RE: SYDNEY METRO CROWS NEST OVER STATION DEVELOPMENT (SSD 9579)

Concept Development Application (SSD 9579) for an OSD above the Crows Nest Metro station including maximum building envelopes, gross floor area, conceptual land uses, car spaces and signage zones

Sydney Metro Crows Nest Over Station Development

2 SITE PLAN - GROUND LEVEL
1:1000

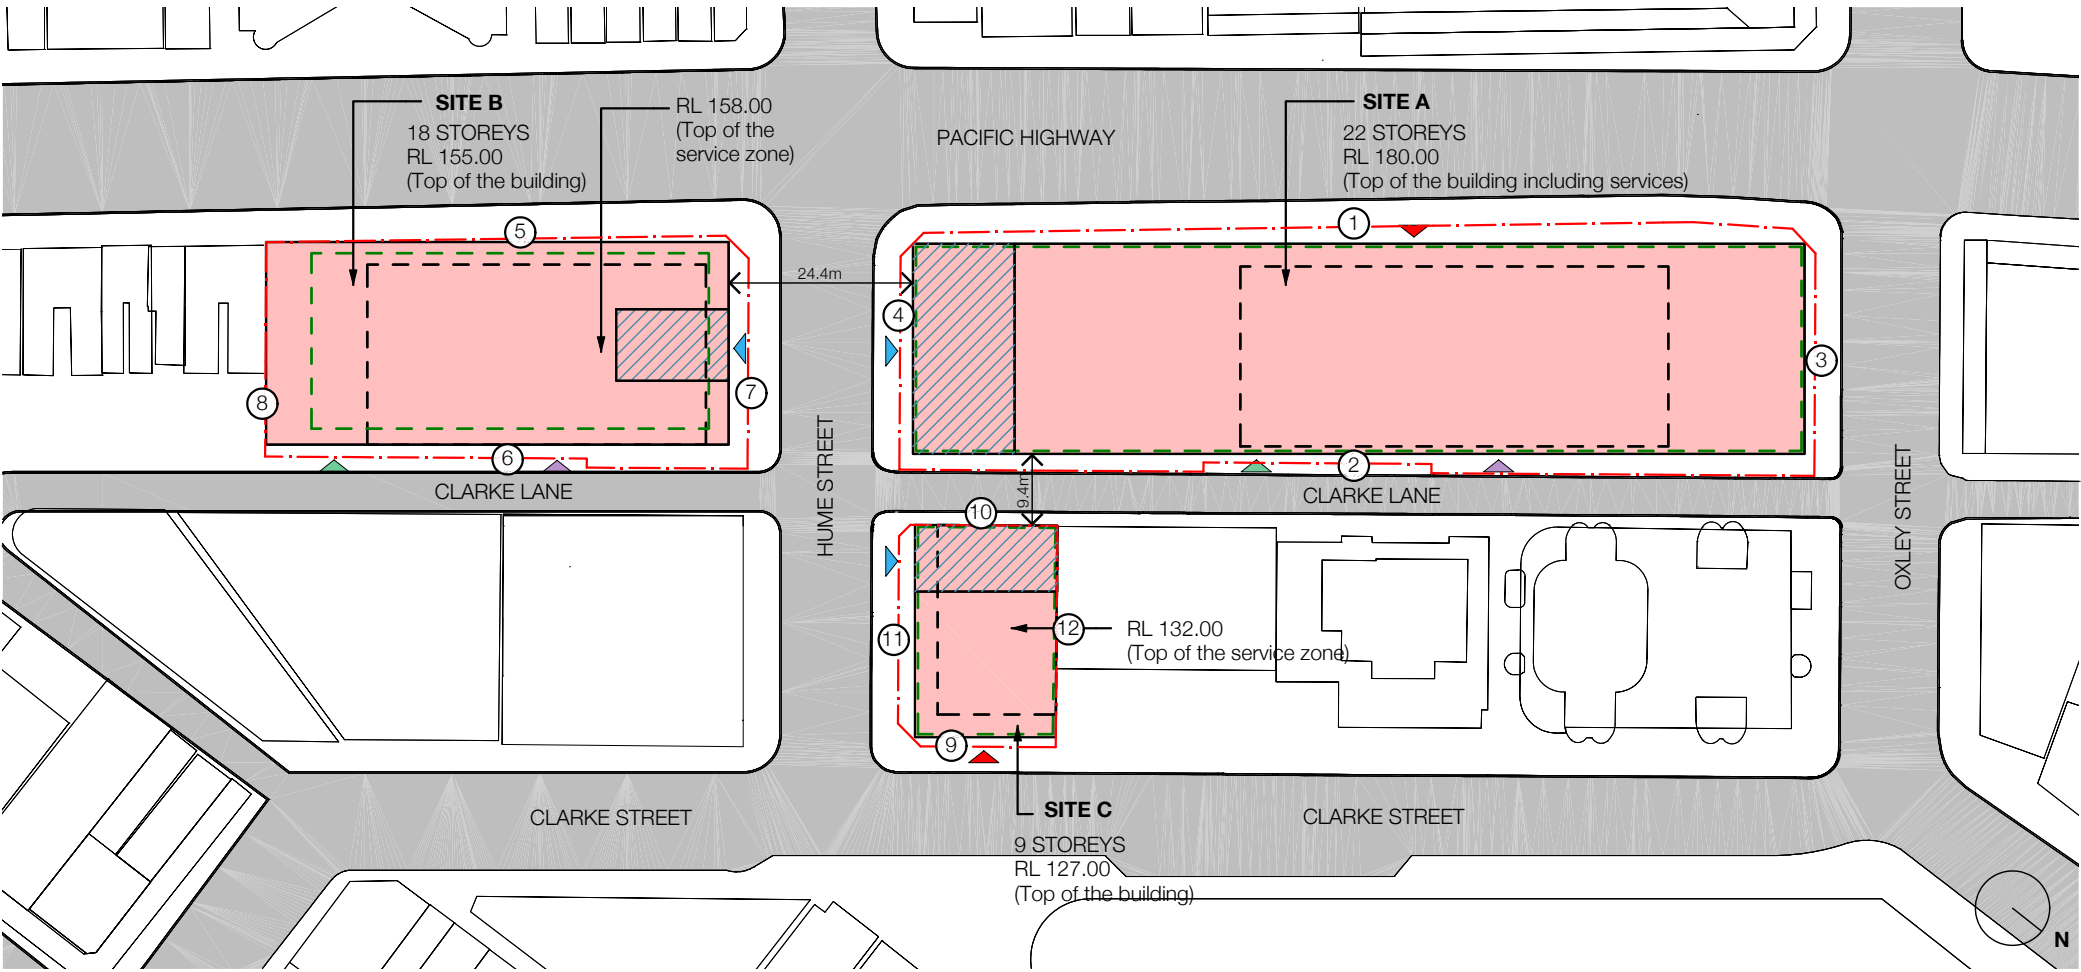
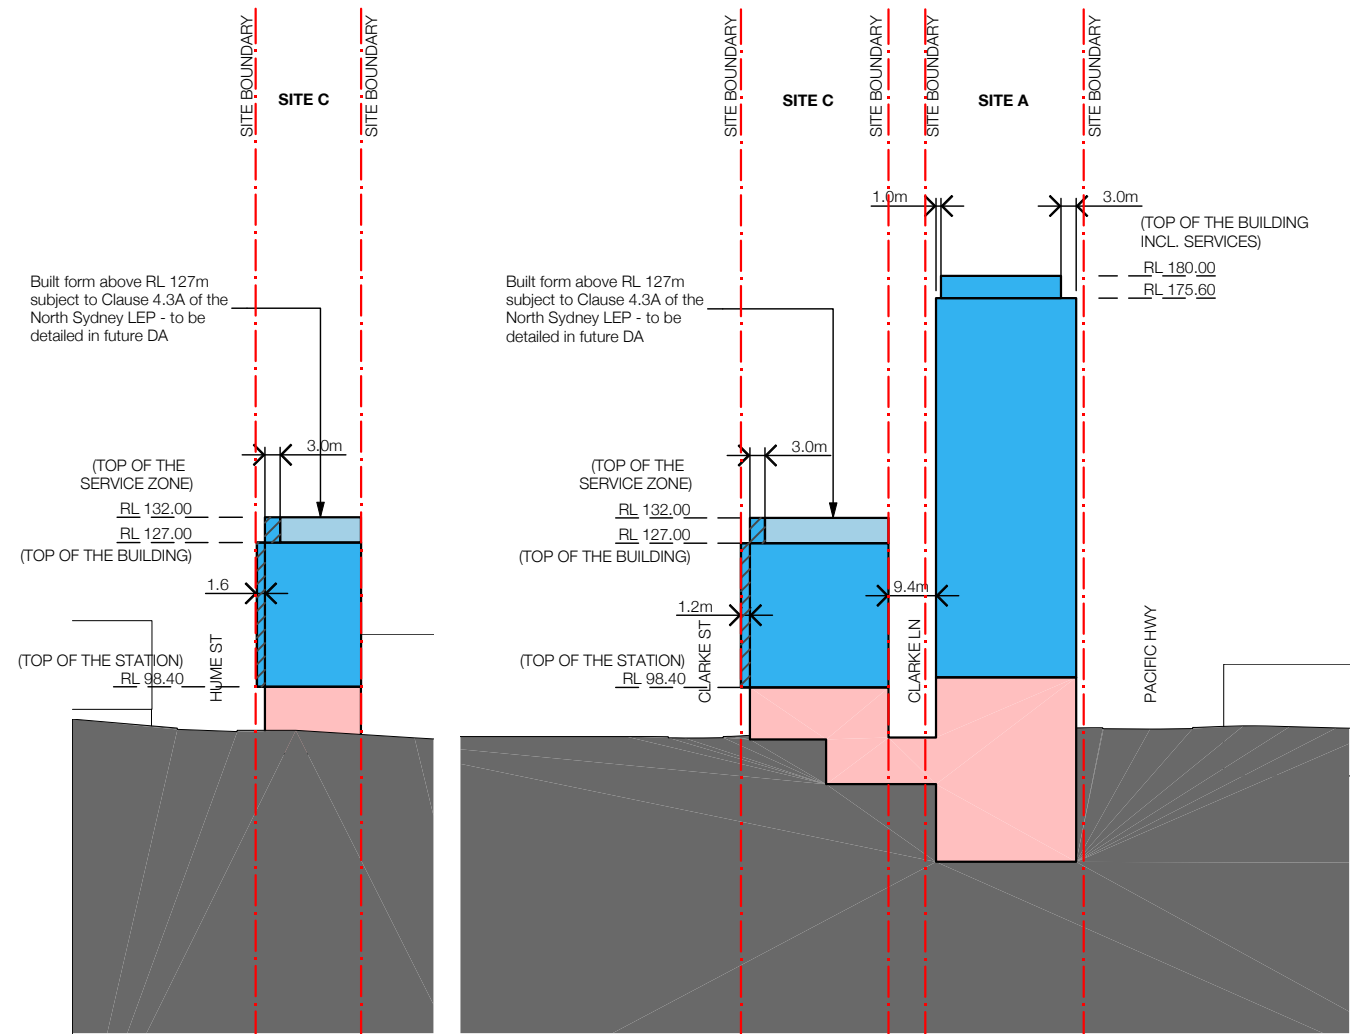
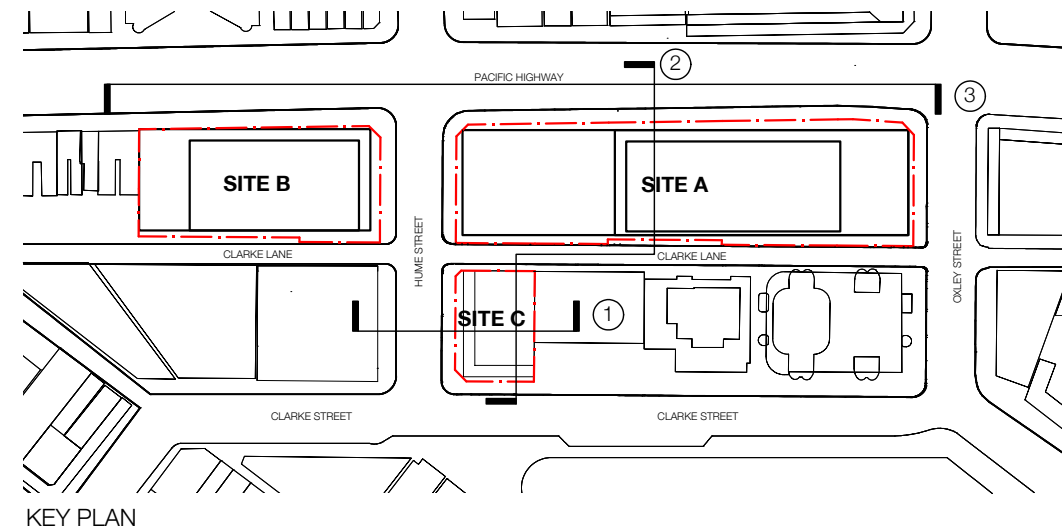
No setback shown on southern boundary of building B. This is a residential building needing to satisfy SEPP 65 separation distances. The adjoining development is likely to be an eight-storey mixed use building with 2 storey podium. Above podium development would be apartments. An absolute minimum side setback of 3m should be provided on each side to allow for some minimum separation, light and ventilation. The finalised form must not borrow or rely upon adjoining sites for separation.

The set back of building B to Clarke Lane is an issue to ensure adequate separation between future residential buildings on the other side of the lane.

Council requires the minimum setback be provided where there is a non-compliance (most sites) having regard to the massing of the buildings. Articulation of the building could be provided by providing a weighted setback where the average setback is at least equal to the DCP requirement. The proposed setbacks might be the absolute minimum but would be compensated for greater than 3m setbacks to ensure the weighted average of setbacks being 3m.
